El Paso County Park Advisory Board

Agenda Item Summary Form

Agenda Item Title: Grandview Reserve Phase II PUD Development Plan and Preliminary Plan

Agenda Date: February 14, 2024

LANDSCAPE  
 PRELIMINARY LANDSCAPE PLAN (OVERALL)

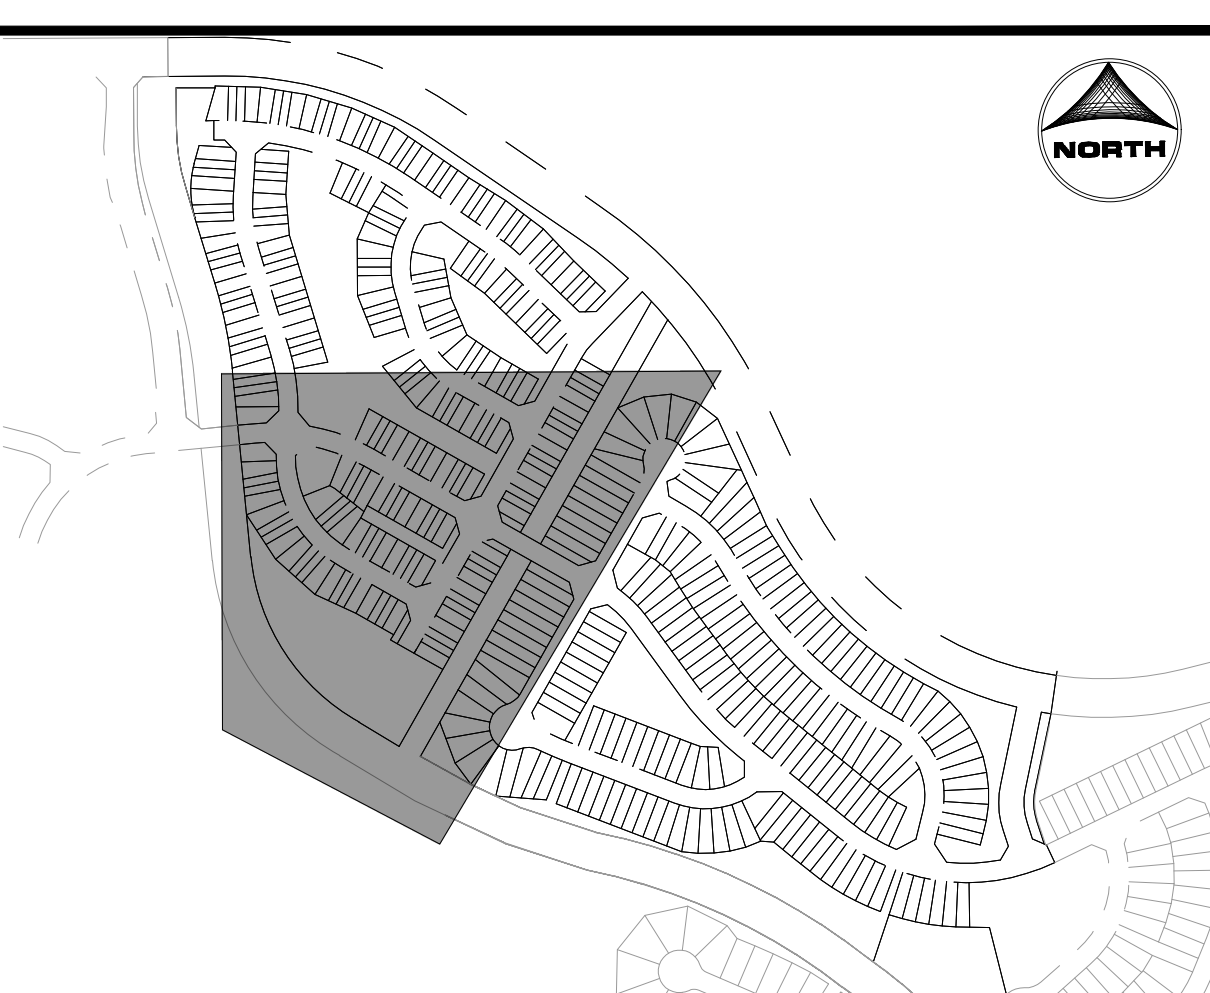
EPC staff is encouraged by the applicant’s willingness to provide extensive recreational amenities for its residents and citizens of El Paso County through the development of an expansive and connected park, trail, and open space system. Staff recommends that the applicant submit detailed site plans for the proposed neighborhood park and include multi-generational recreational amenities such as a playground, multi-use turf field, and/or seating and picnic areas. The submitted Landscape Plans are rather limited and only show half of the proposed park area.

The Park Advisory Board recommends that the Planning Commission and the Board of County Commissioners include the following conditions when considering and/or approving the Grandview Reserve Phase II PUD Development Plan and Preliminary Plan: (1) provide detailed site plans for the proposed neighborhood park; (2) fees in lieu of land dedication for regional park purposes in the amount of \$211,090 and urban park purposes in the amount of \$126,654 will be required at time of the recording of the forthcoming Final Plat(s). A Park Lands Agreement may be an acceptable alternative to urban park fees provided the agreement is approved by the County and executed prior to recording the forthcoming Final Plat(s).
